CDS is requesting comments on the following Conditional Use application: CU-25-00001 Hayford Well.

Subject: CU-25-00001 Hayford Well

TO: All Staff
FROM: Public Works Plan Review Team
DATE: February 10, 2025
SUBJECT: CU-25-00001 Hayford Well

SUBJECT: WDFW COMMENTS ON CU-25-00001 HAYFORD WELL COMMUNICATIONS TOWER

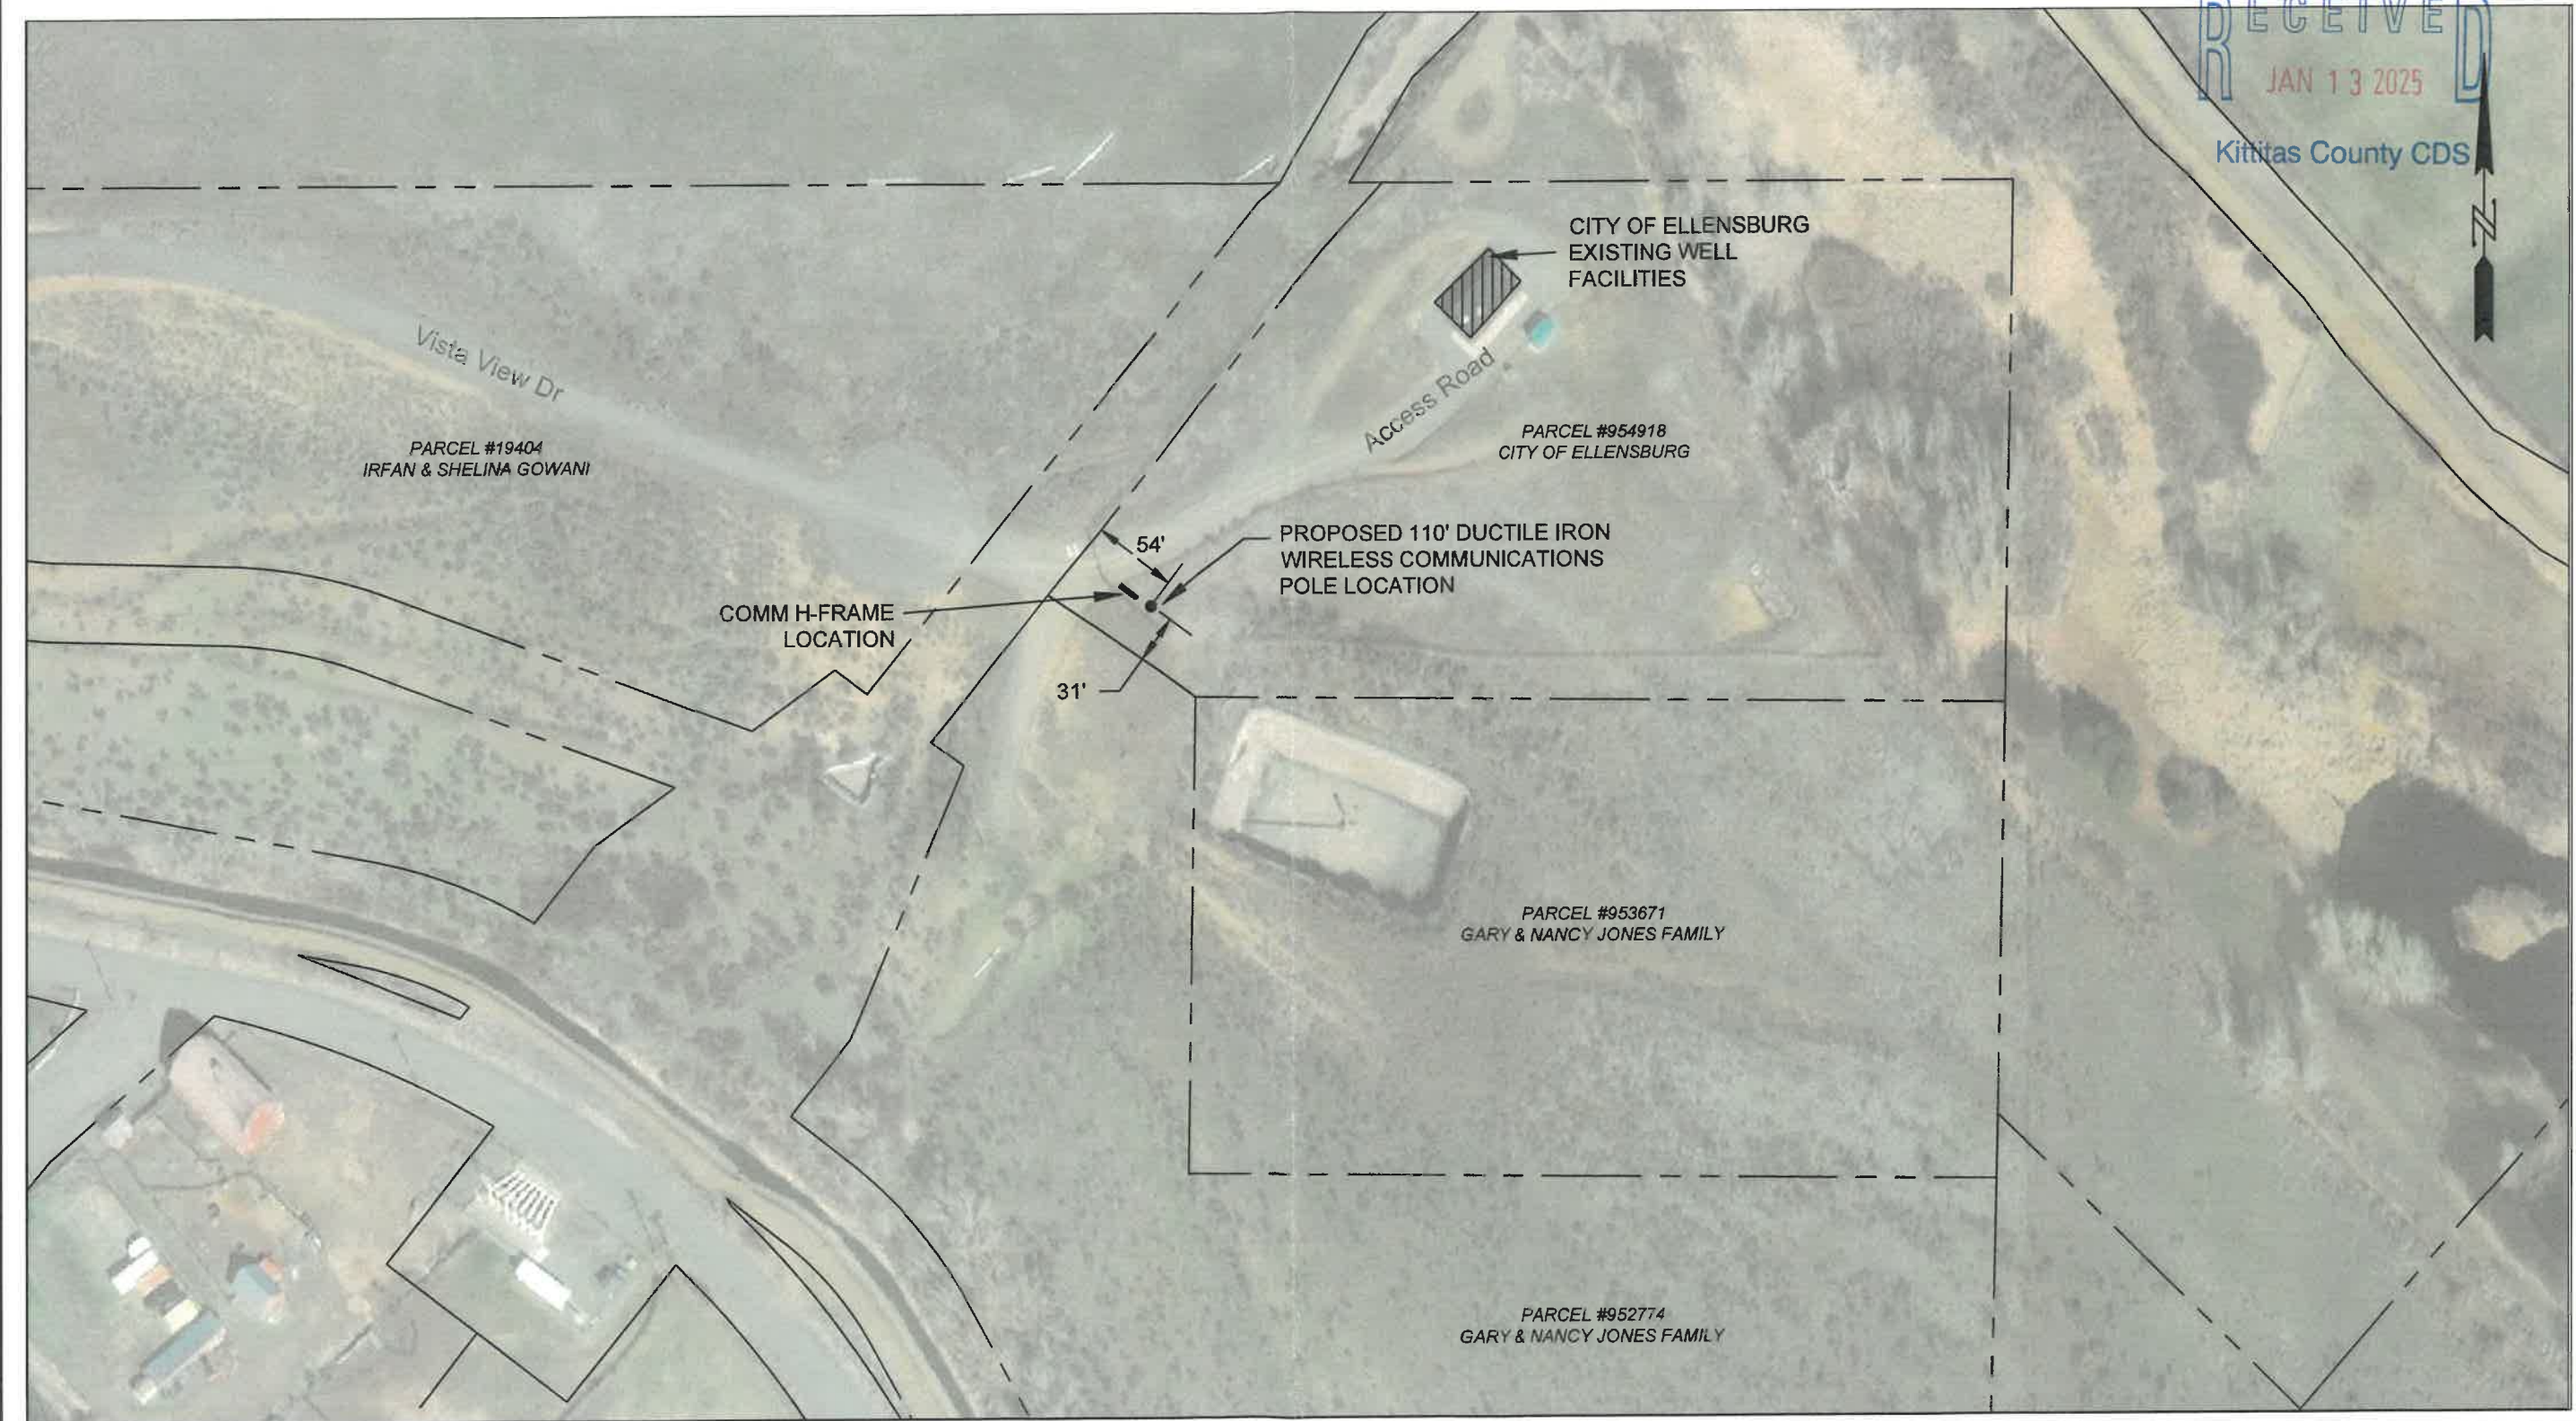
1. What is the pole's distance from the well?
2. How will service and maintenance vehicles access the pole, and where will they park?

The application materials available for review do not discuss the overall area of disturbance for this project and do not address the potential impacts to shrubsteppe habitat with construction of this project. **We request that a complete site plan be provided that includes all temporary and permanent disturbance so all potential impacts to shrubsteppe habitat can be reviewed and properly mitigated for, consistent with the County's critical areas ordinance.**
